Your Ref :
Our Ref : A/61/13/NMA

**Application for a non-material amendment following a grant of planning permission A/53/12 -
Removal of unprotected Maple tree. Replanting of a new sappling once building is complete
Land south of Mill Cottage, Old Mill Lane, Angmering.**

C/No. 134485	O/No.	SCALE 1:100/1:500
DATE 4/12	DRAWN SW	DRAWING NUMBER 01L
		REV C

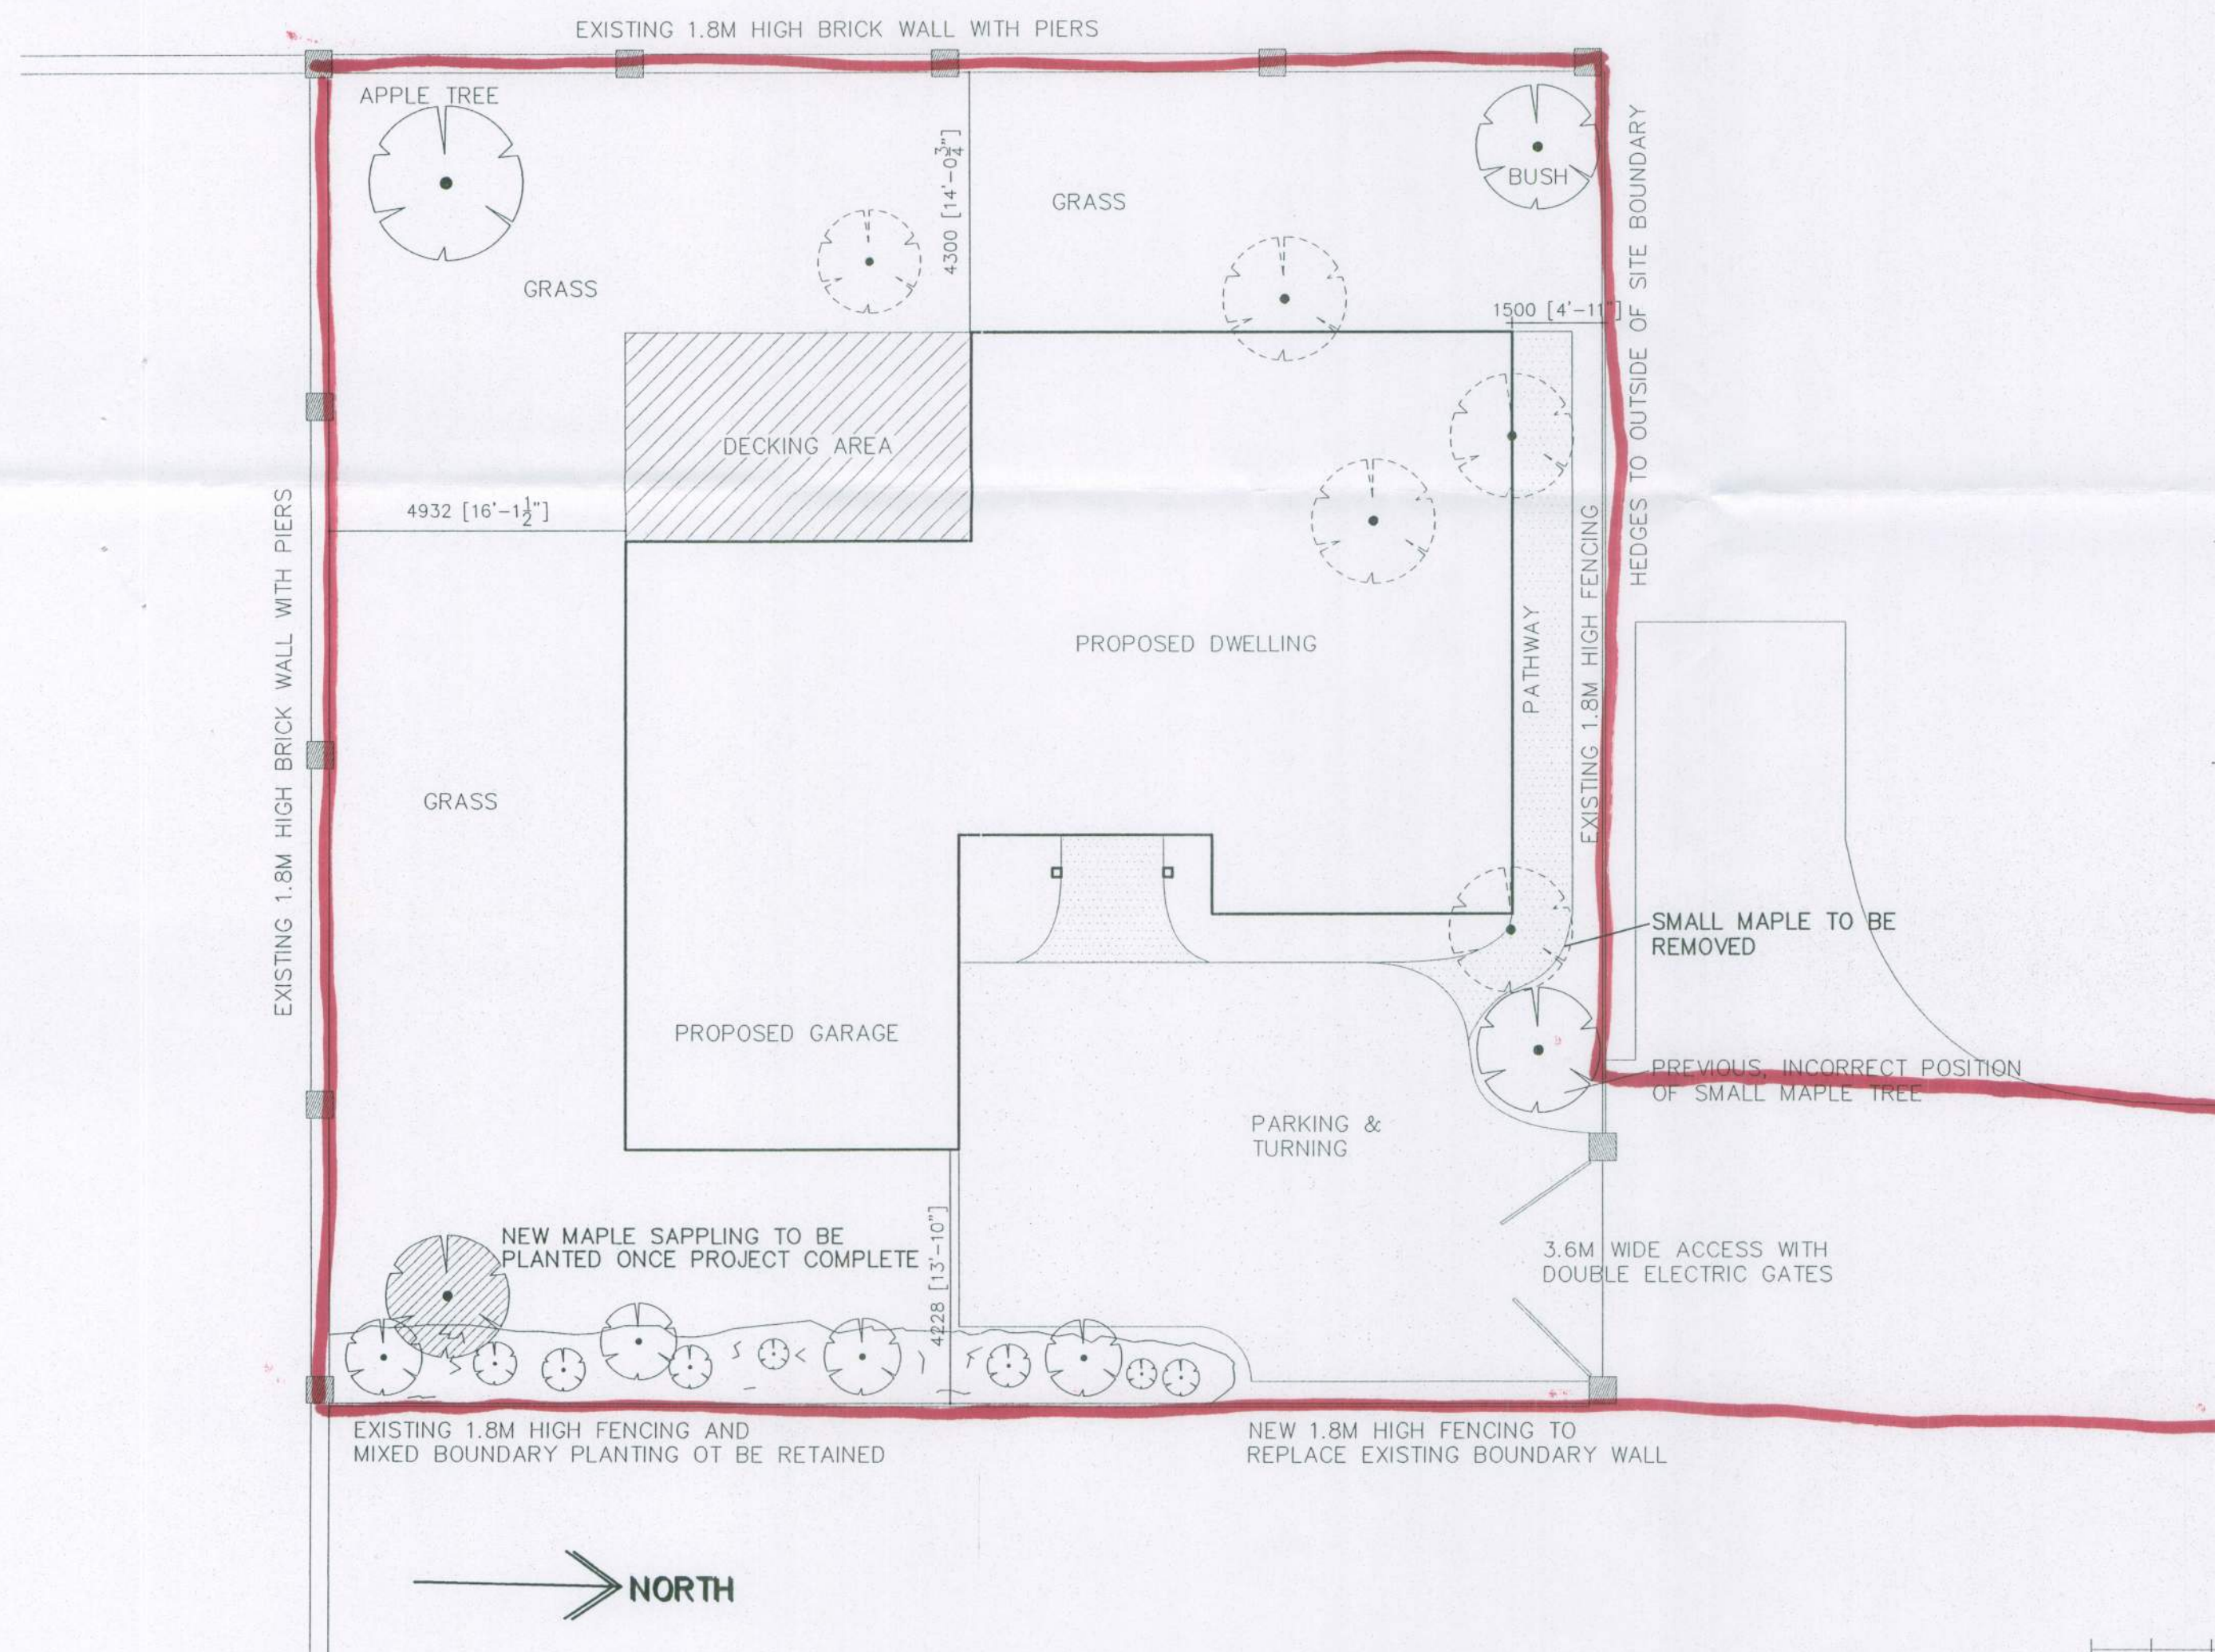
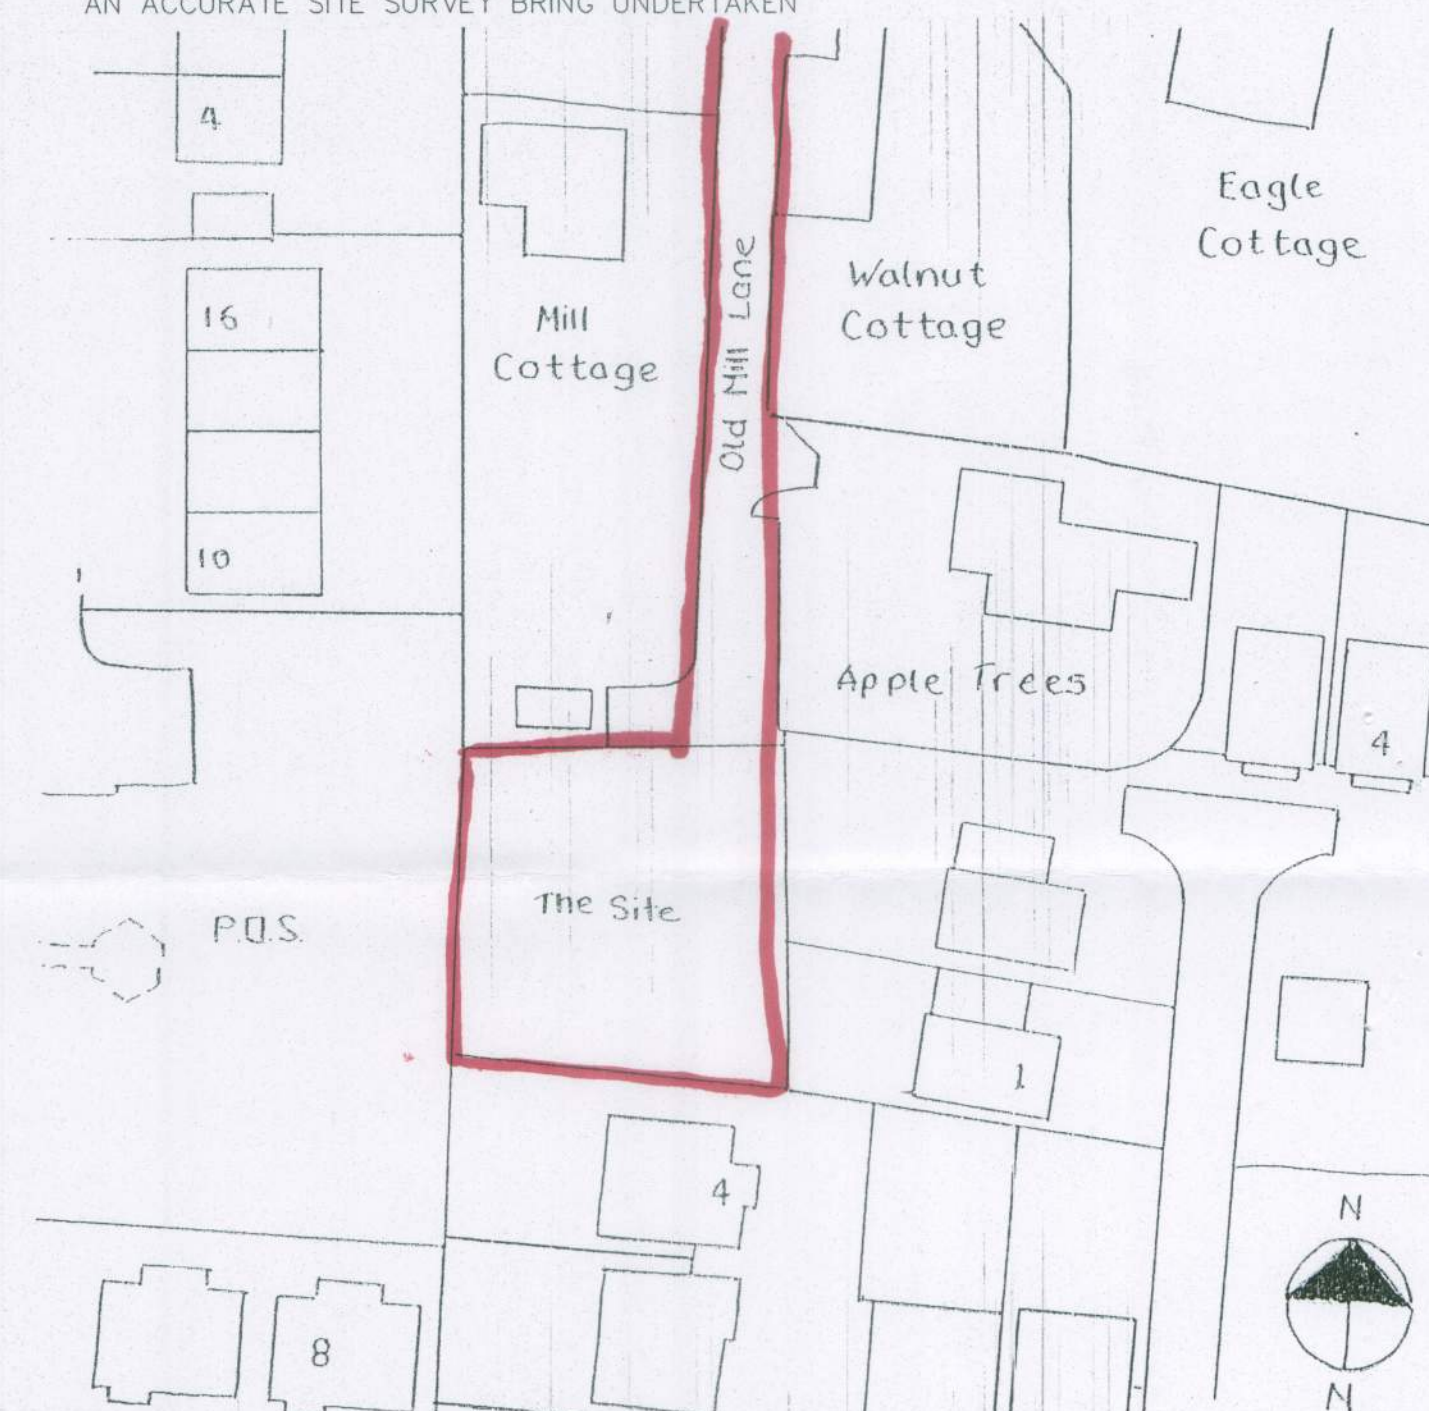
The changes proposed include the removal and replacement of a Maple tree within the site and therefore an amendment to the approved site plan listed in Condition 2 of the approval. Condition 2 is duly amended to refer to the revised plan as set out below.

1:1250 Location plan;
Drawing No.s 01L Rev C; X01 Rev D; X02 Rev D; X03 Rev E.
